From: Hannah Kersley
Sent: 06 January 2025 09:19
To: Planning.Responses
Subject: FW: BR/232/24/HH - 11 Chichester Road
Attachments: CHICHESTER ROAD PL 304 A - PROPOSED.pdf; BR-232-24-HH request.docx

From: Oleksandr Sapozhnyk [REDACTED]
Sent: 04 January 2025 20:06
To: Hannah Kersley <Hannah.Kersley@arun.gov.uk>
Subject: Re: BR/232/24/HH - 11 Chichester Road

11 CHICHESTER ROAD  
BOGNOR REGIS  
PO21 2XG  
PROPOSED PLANS AND ELEVATIONS  
(SC. 1:100 @ A3)  
DRAWING NO: PL 304  
NOV 2024

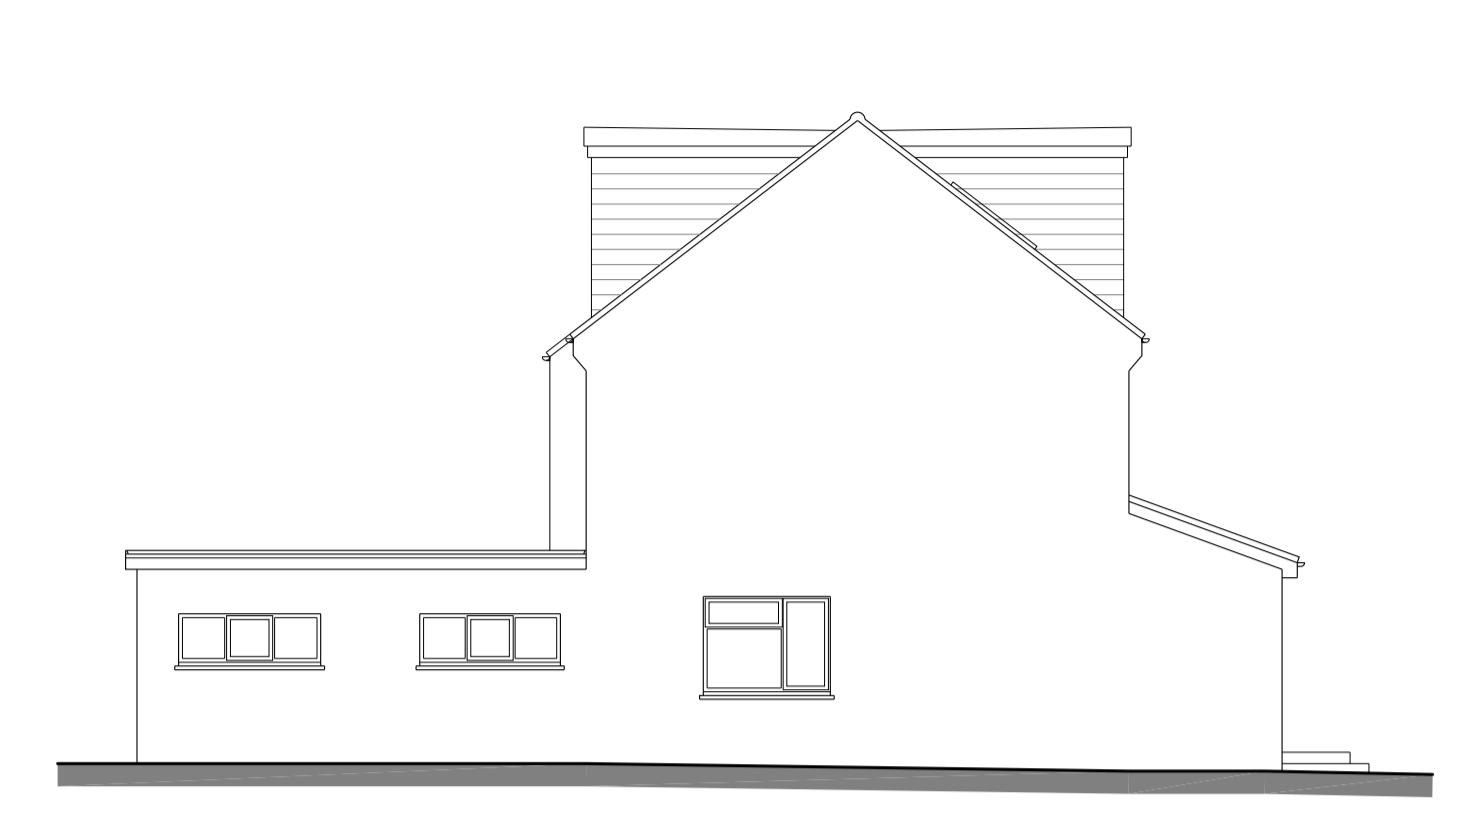
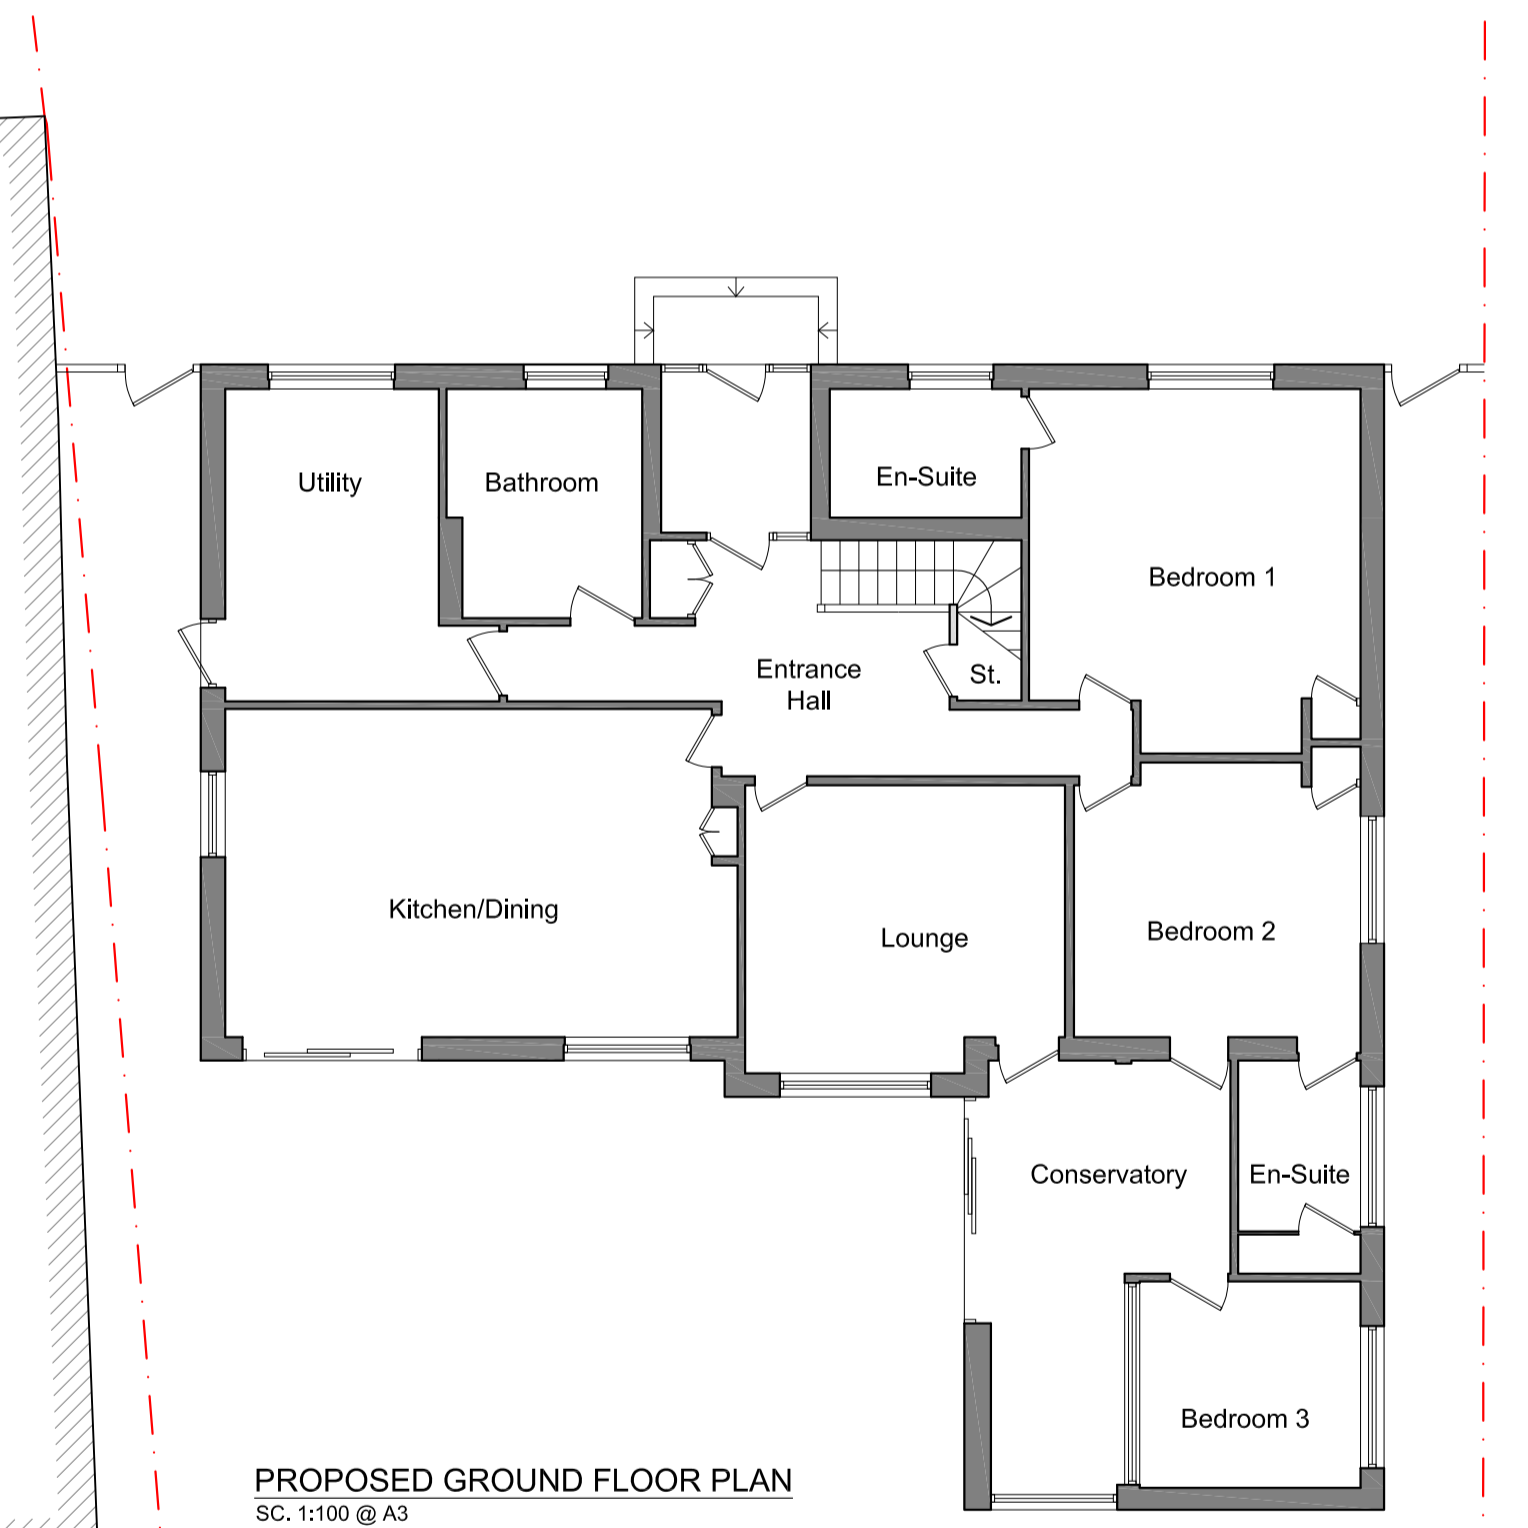
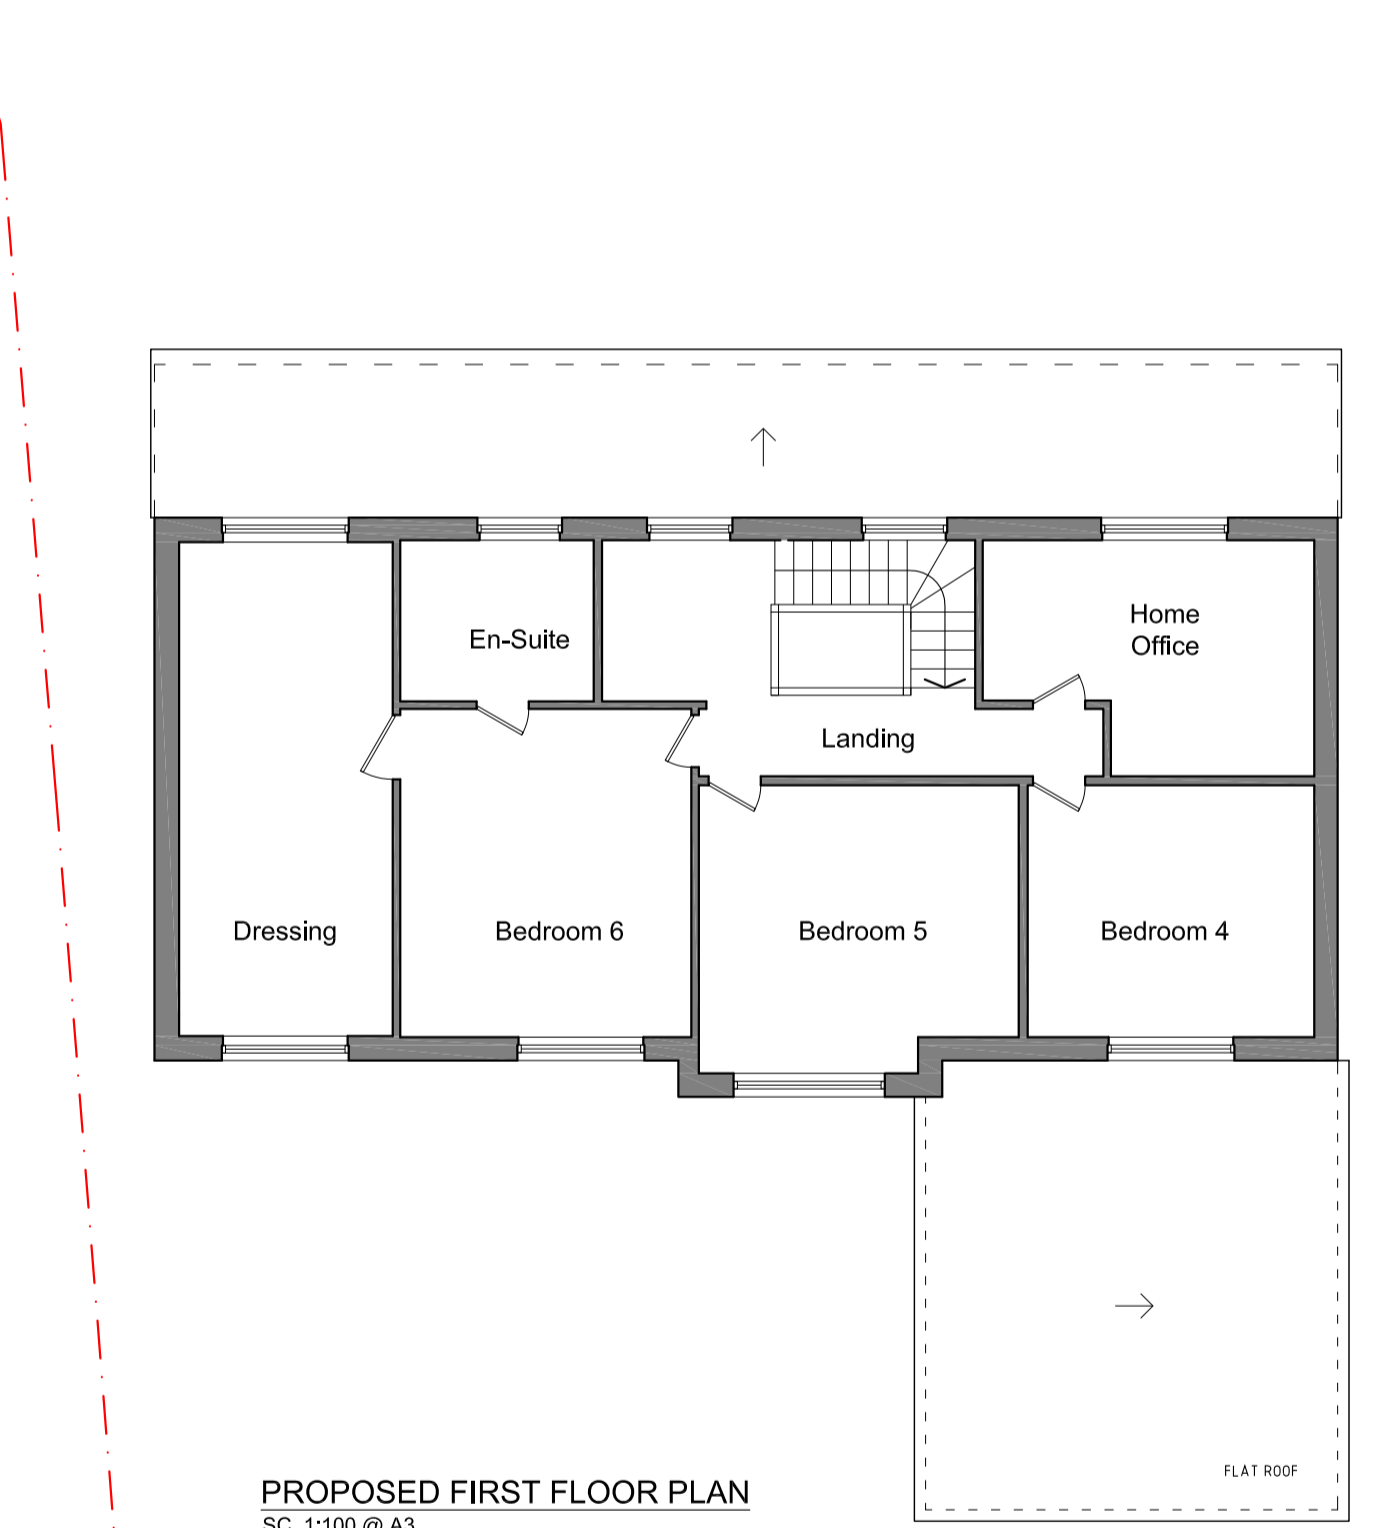
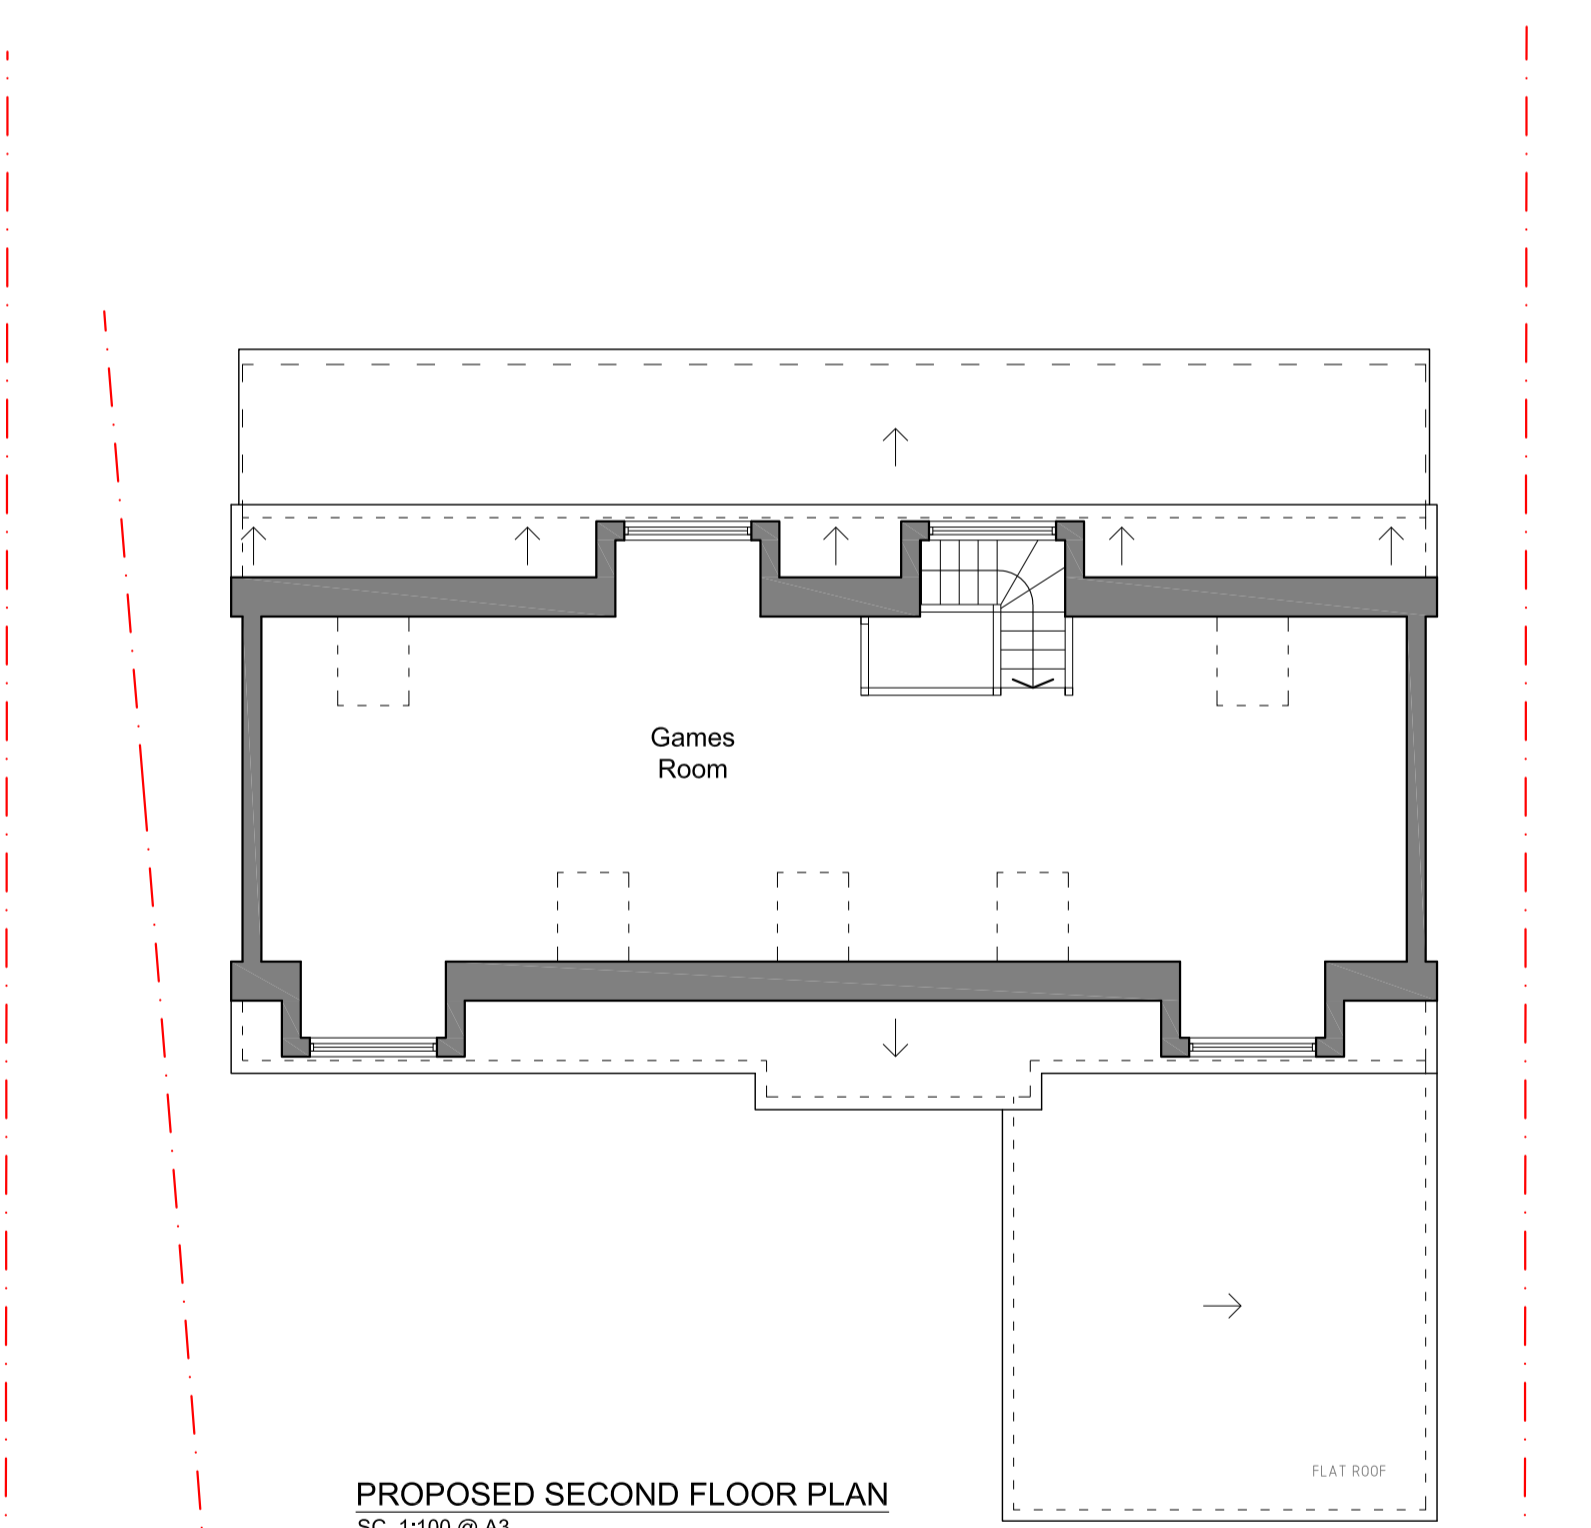
I have assessed the proposal and discussed with my manager. I can advise that we are happy to accept the dormers and rooflights to the front elevation. However, we do have significant concern with the dormers to the rear, and the overbearing impact this would have on neighbouring properties nearby. Whilst we do also appreciate the windows on the dormers have been obscure glazed, there will be a perception of overlooking, which is not acceptable. As such, as the proposal stands, we cannot support the application, and would need to recommend it for refusal on the grounds of harm to neighbouring amenity.

However, were you to be happy to remove the rear dormers, and replace these with rooflights, I can advise that we would be more amenable to recommending approval. Should a rear dormer be absolutely necessary, we would need to insist that only one be proposed, and this be minor in scale and with no window – preferably with a gable or hipped roof if possible to reduce its prominence on the main roof. This must also not be located towards the north-western edge of the roof, as so to preserve the outlook of residents of Saxby Lodge.

Following your advice we have omitted the rear dormers.

Please find attached the revised PL 304 A drawing.
